4th September 2025

Removal of solar panels south of Oxford Airport

Proposed changes to the DCO Application (July 2025)

**Operational Development Plan
Northern Site Area 1 of 2**

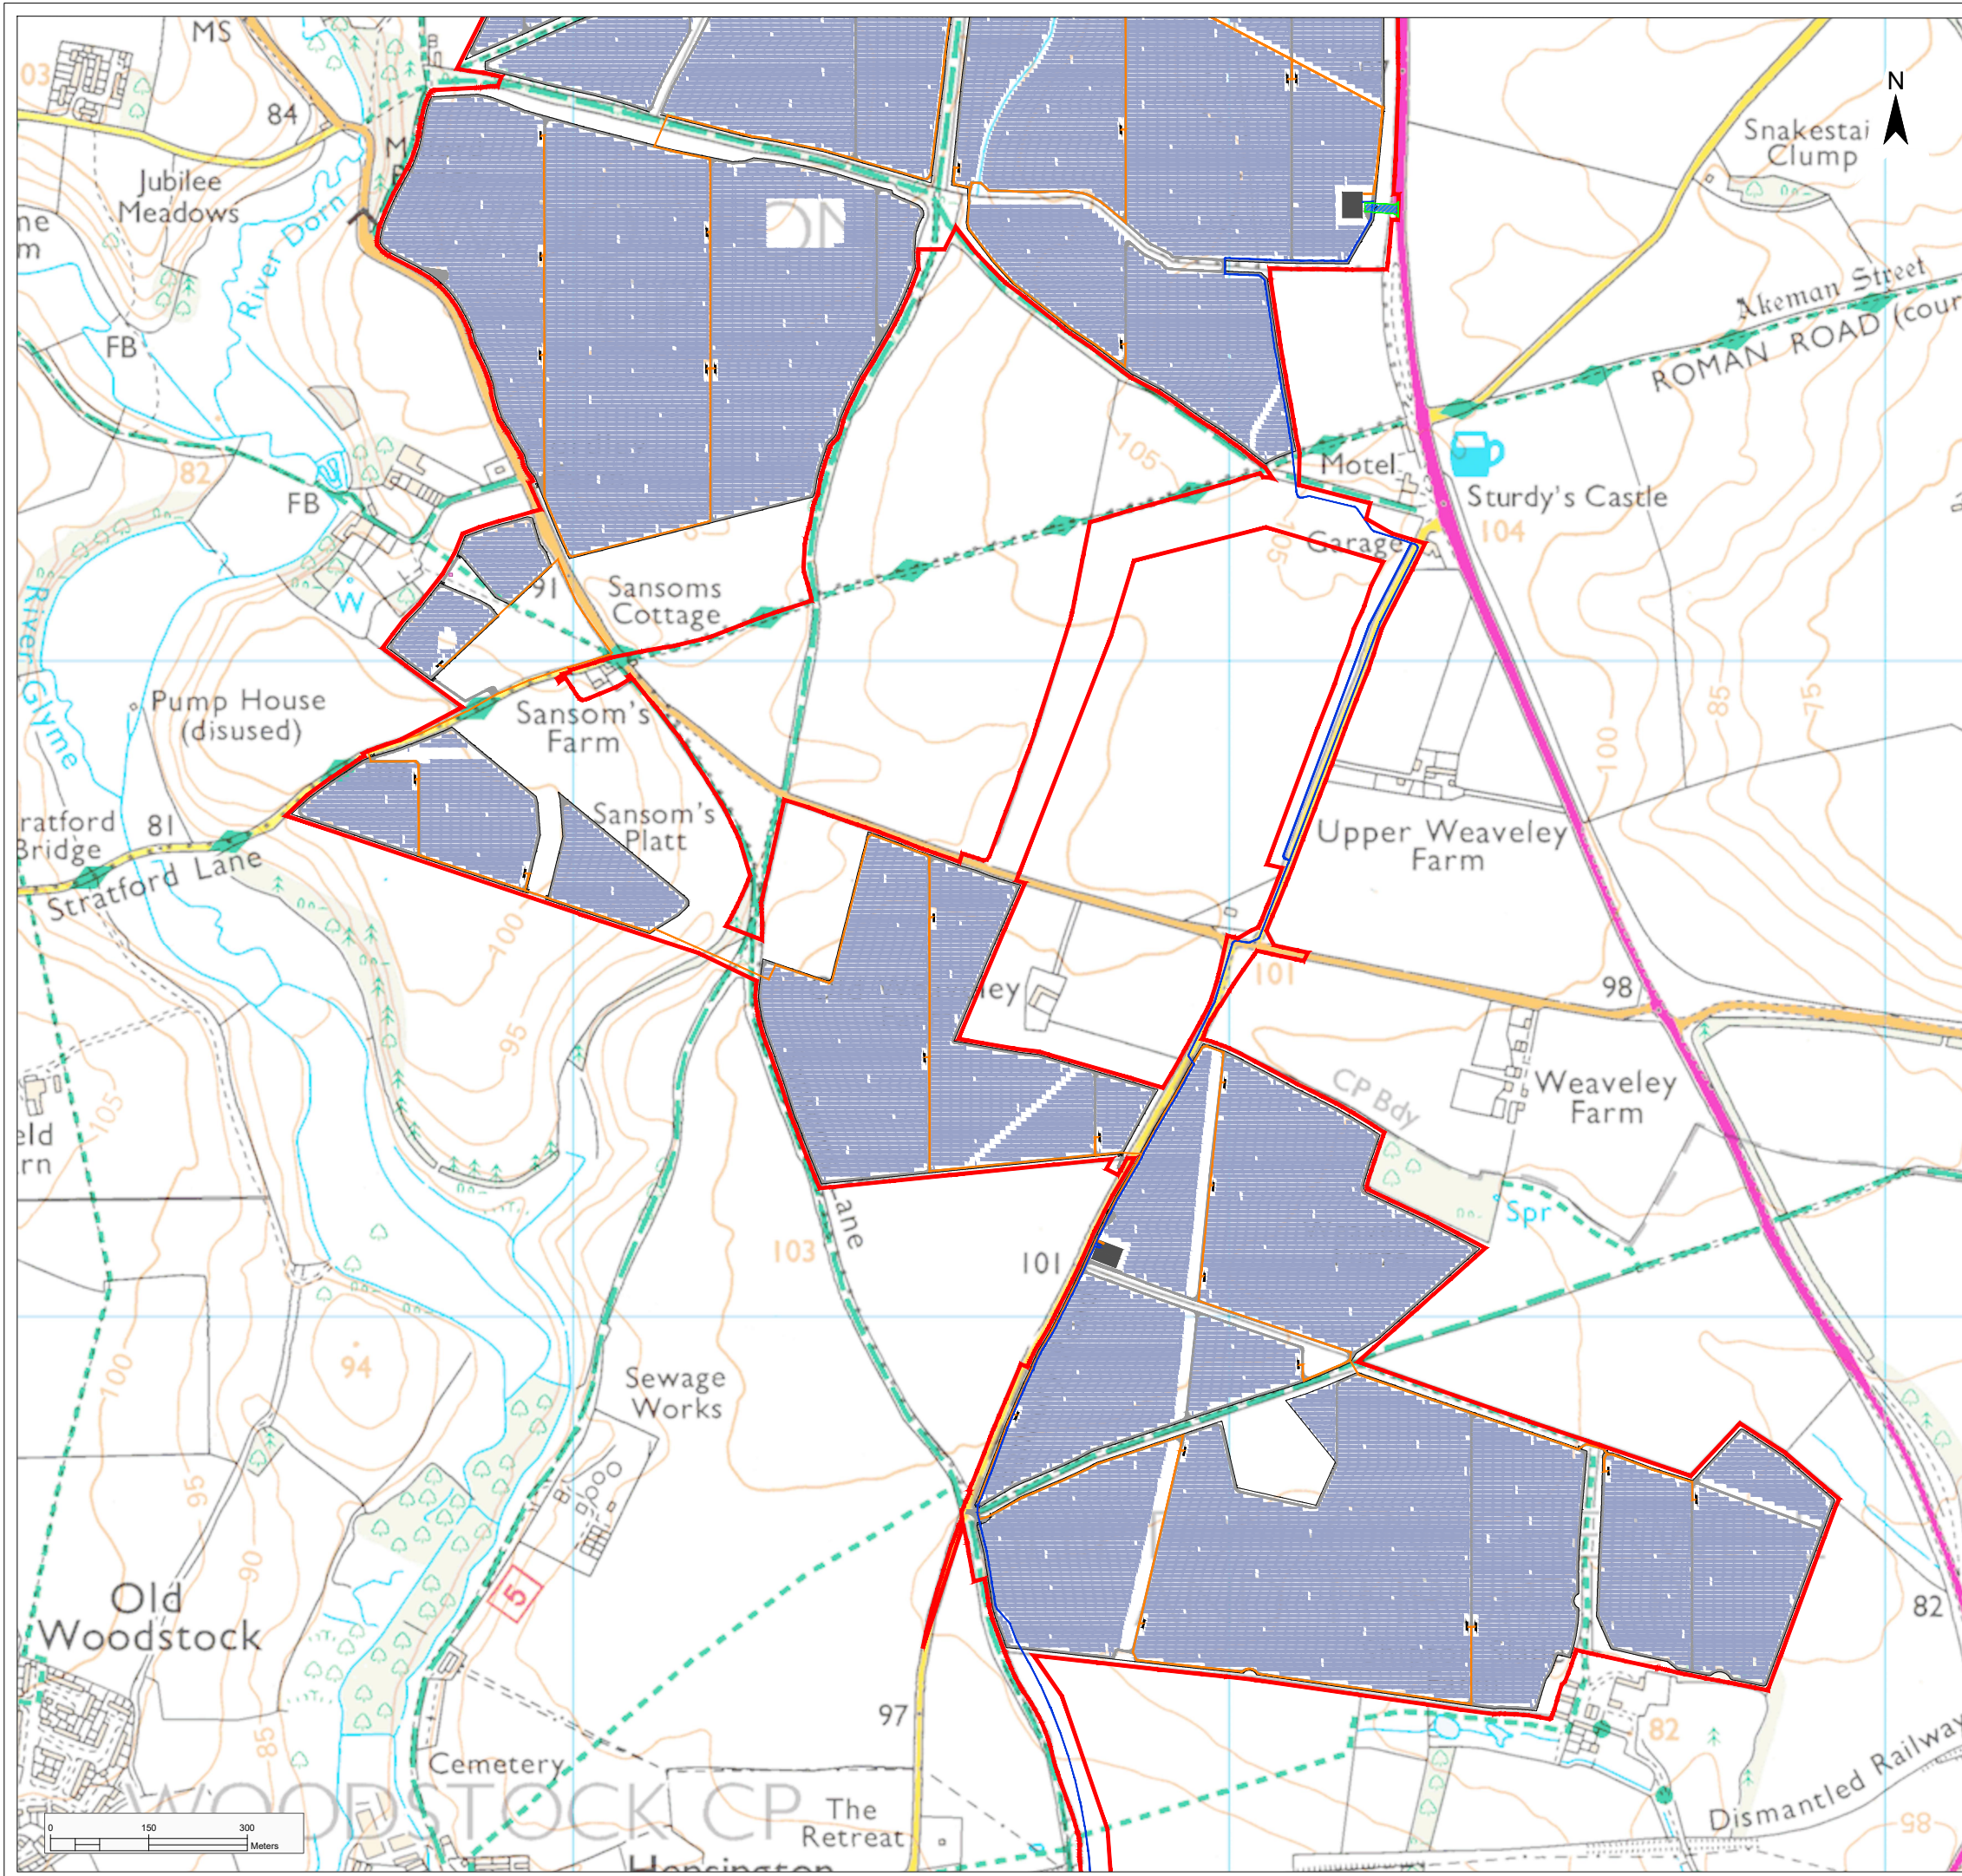
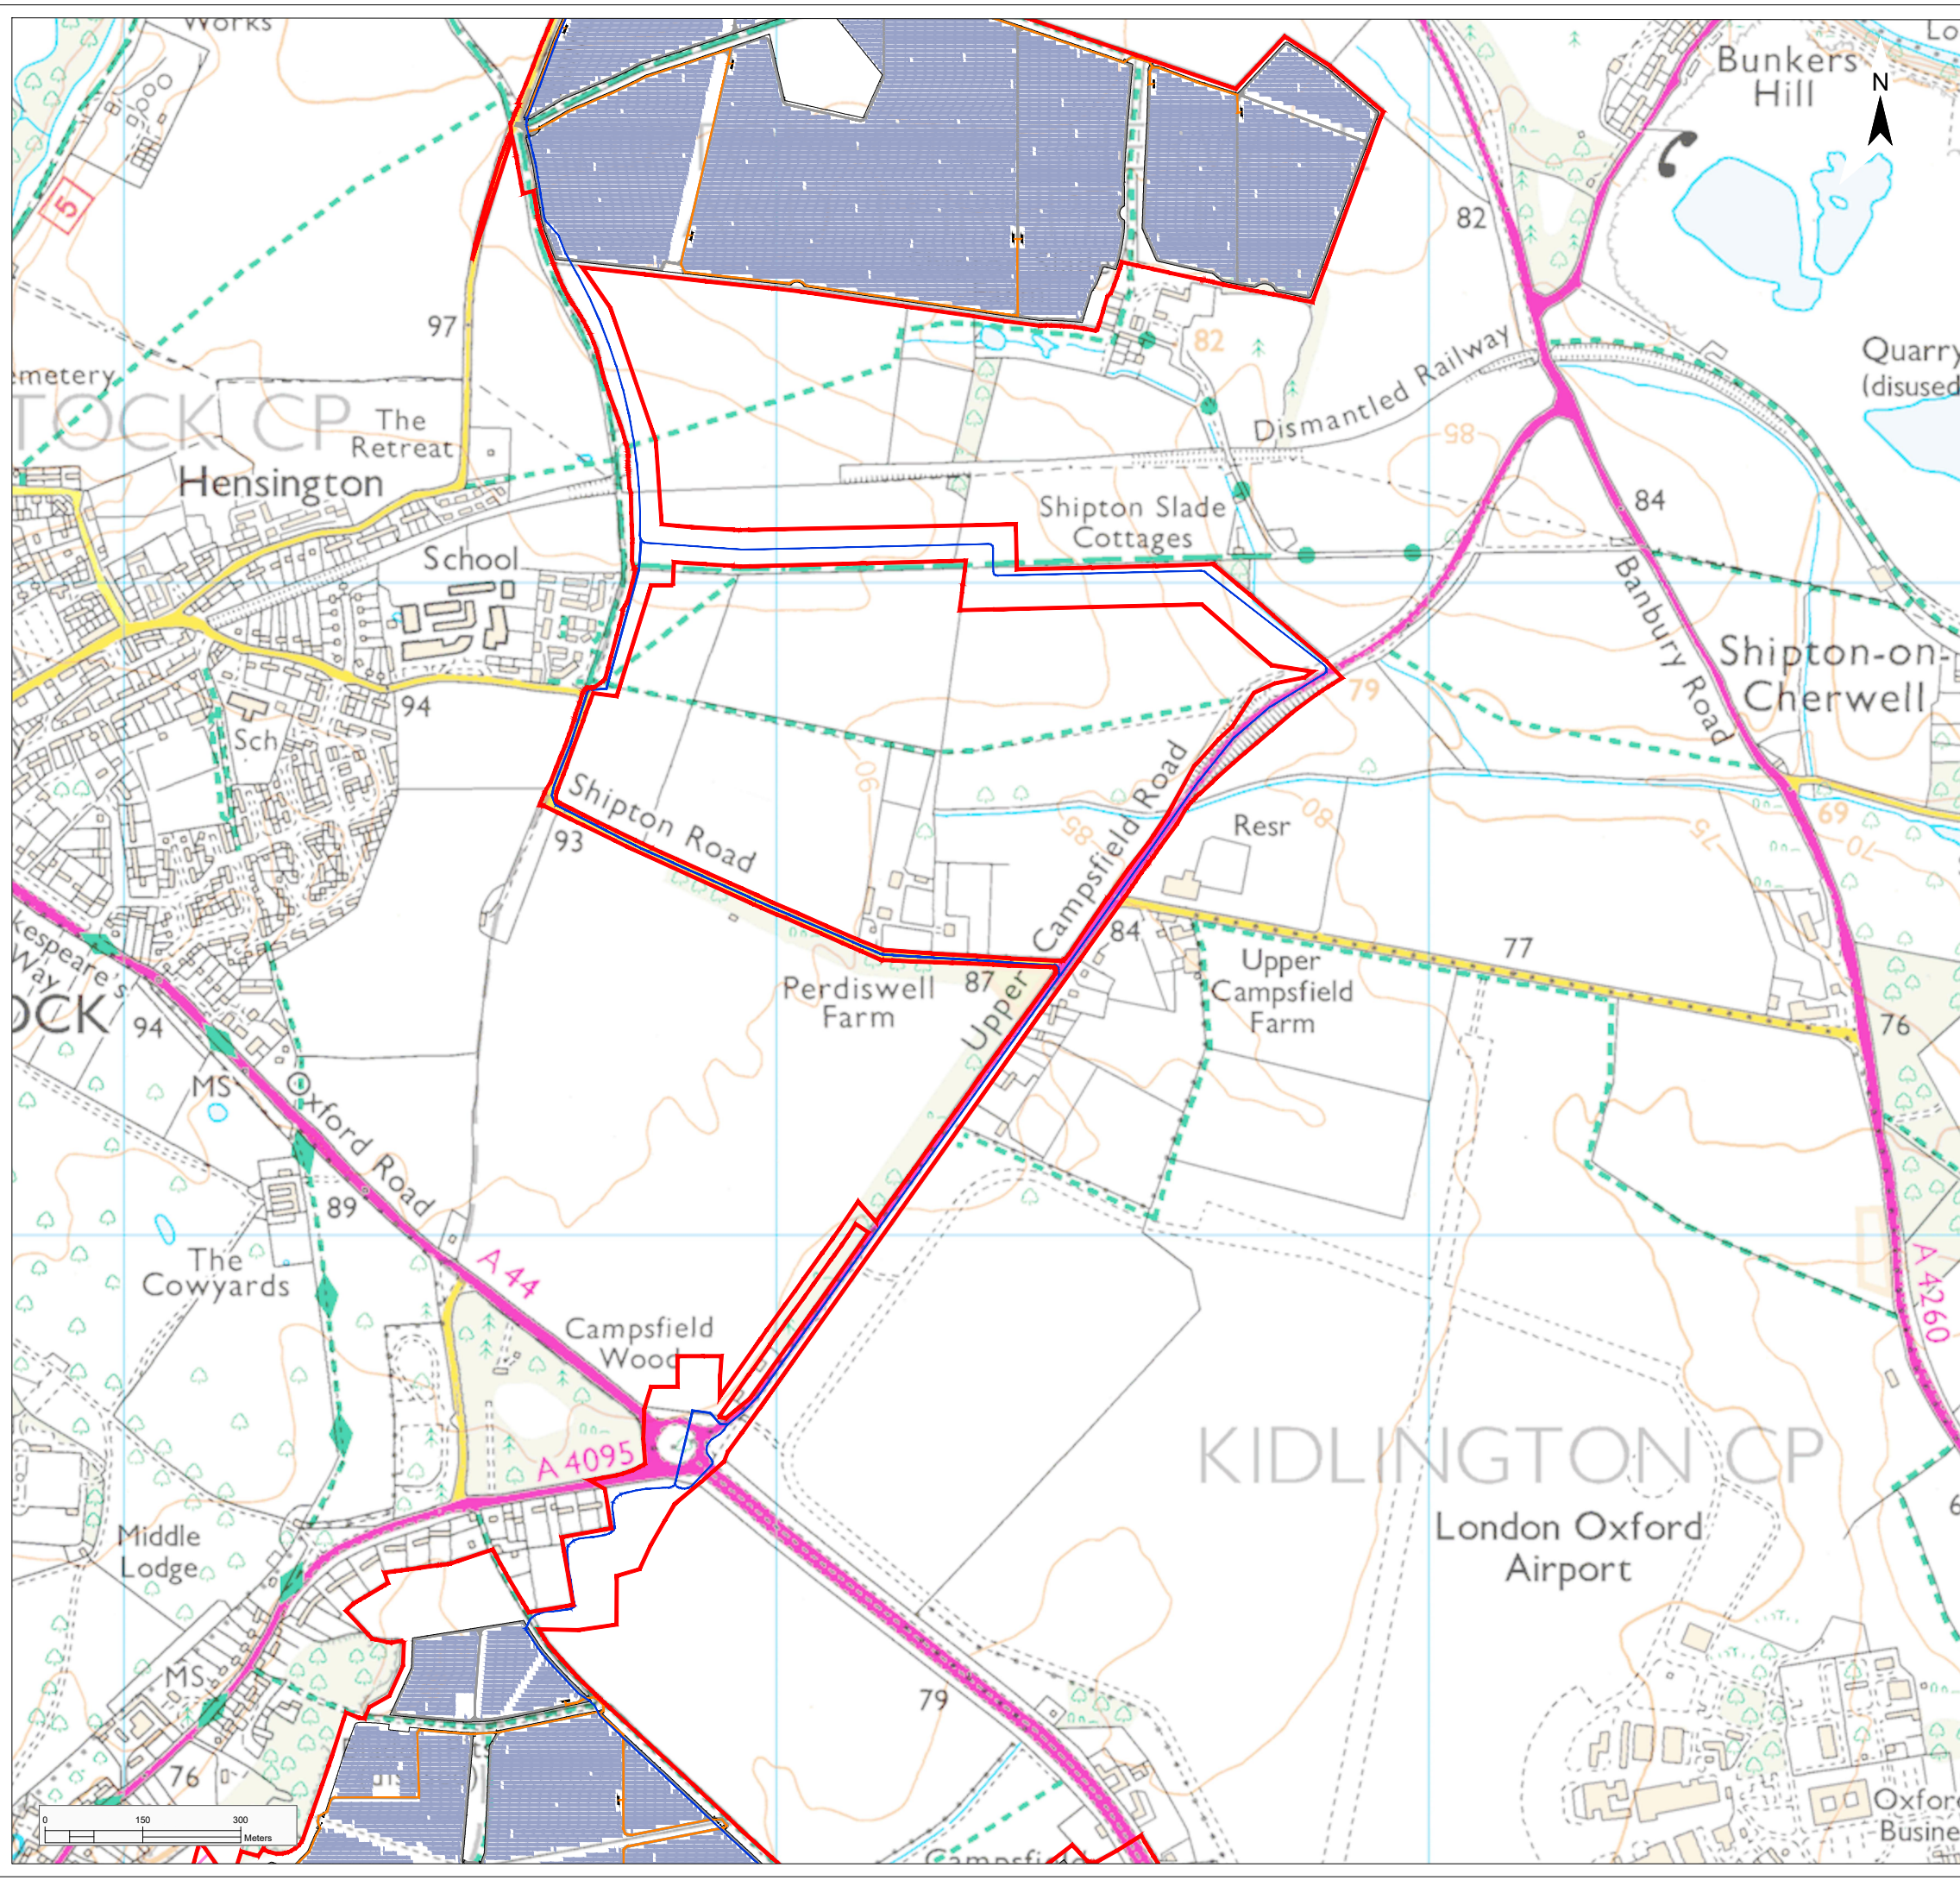
There seems to be a completely unnecessary narrow strip of solar panels on the western edge of field 2.15 next to Bladon Heath Wood. This would destroy the view of the field and wood from Springhill Road and from the bridleway. and would reduce a section of this bridleway to a corridor between the hedge and the high fencing around the small slice of solar farm.

Planning to put solar panels and cables so close to the wood flies in the face of the advice of the Forestry Commission. They recommend a large buffer zone, to protect the trees and creatures of the woodland edge. They also stress the importance of connectivity between areas of woodland. Field 2.15 is a link between Bladon Heath Wood and Begbroke Wood and beyond. Solar panels and their fencing would badly damage this pathway.

Please insist that PDVP remove solar panels completely from field 2.15!
